Planning Application No: 3/2024/0183

Proposal: Proposed extension of garden area and erection of new timber fence.

Location: 6 The Dales Langho BB6 8BW

Location Plan 1:1250

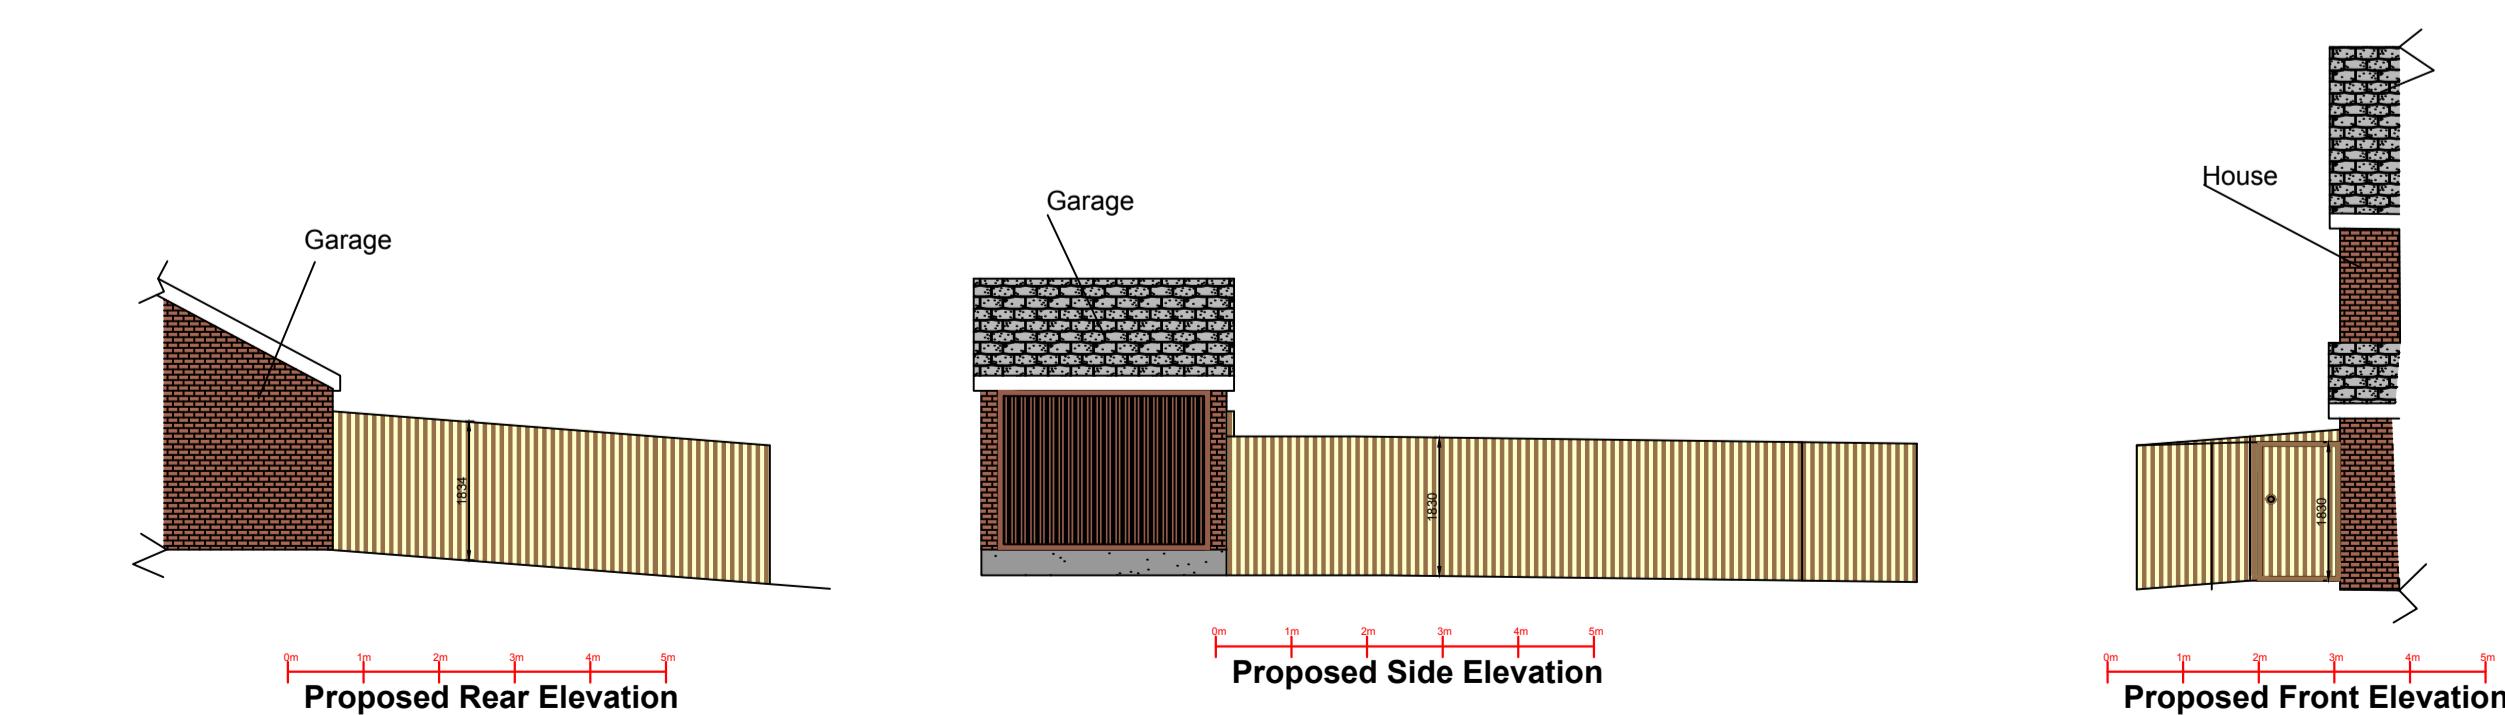
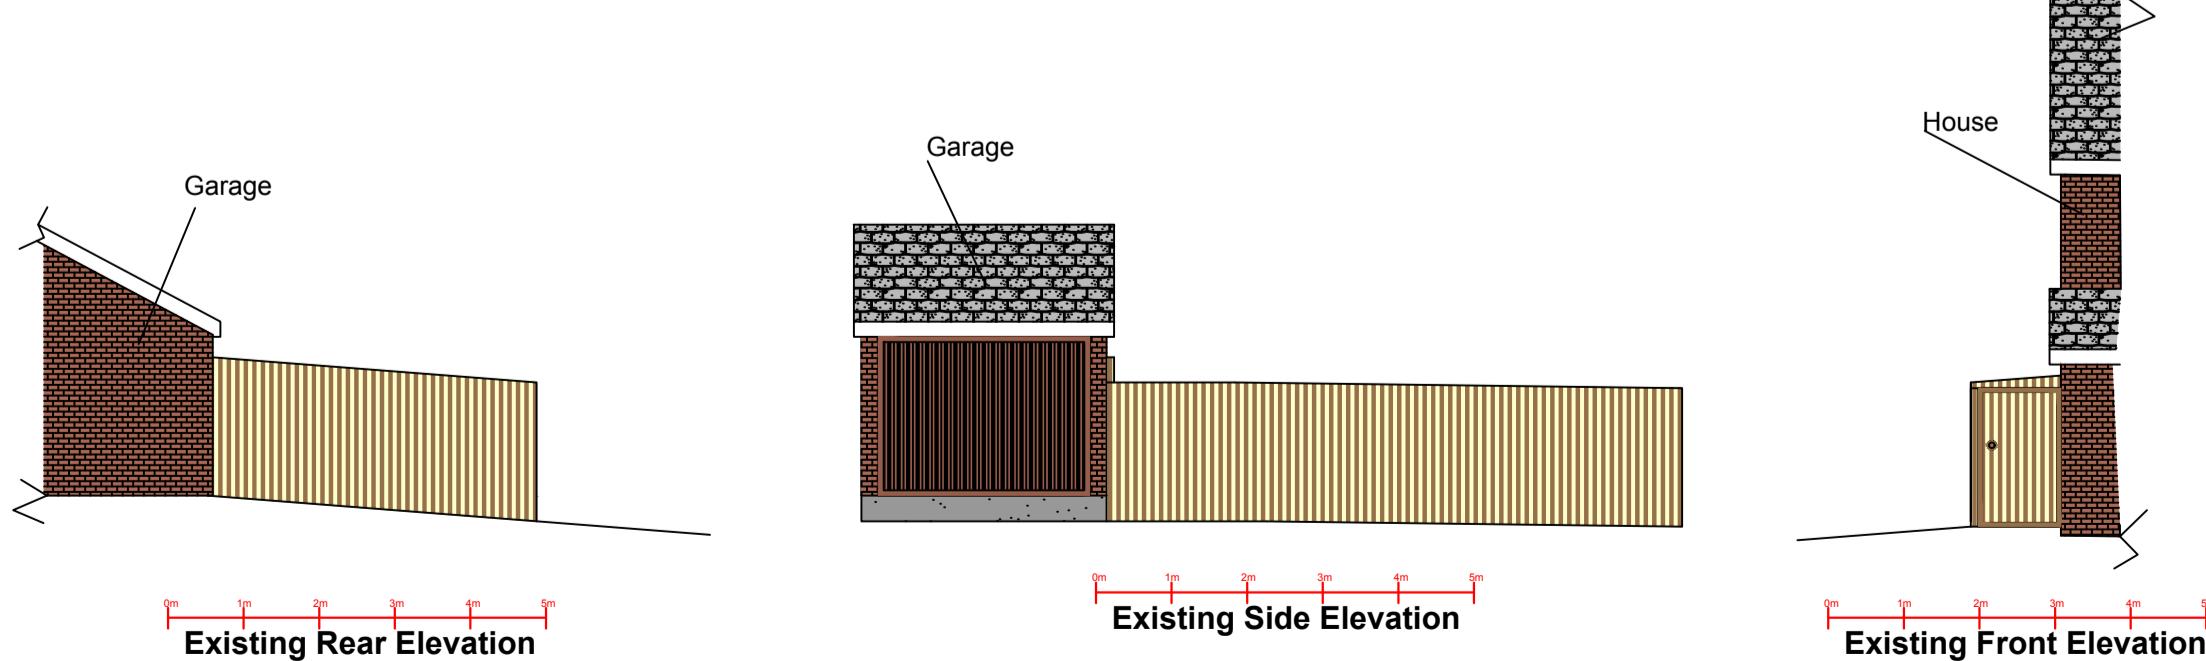
The proposed fence line needs amending at its southern end so that it is set back by 2m, it's currently proposed at 1.6m. As proposed, this would encroach onto the service verge and would obstruct the visibility for the neighbouring driveway and we would raise an objection to this.

Having considered the information submitted, the proposed fence needs to be set back from the carriageway by a minimum of 2m. Although there maybe underground services located further back than that it must be noted that it is the responsibility of the householder to check the records for gas, electric, water, sewer, media and telecoms.
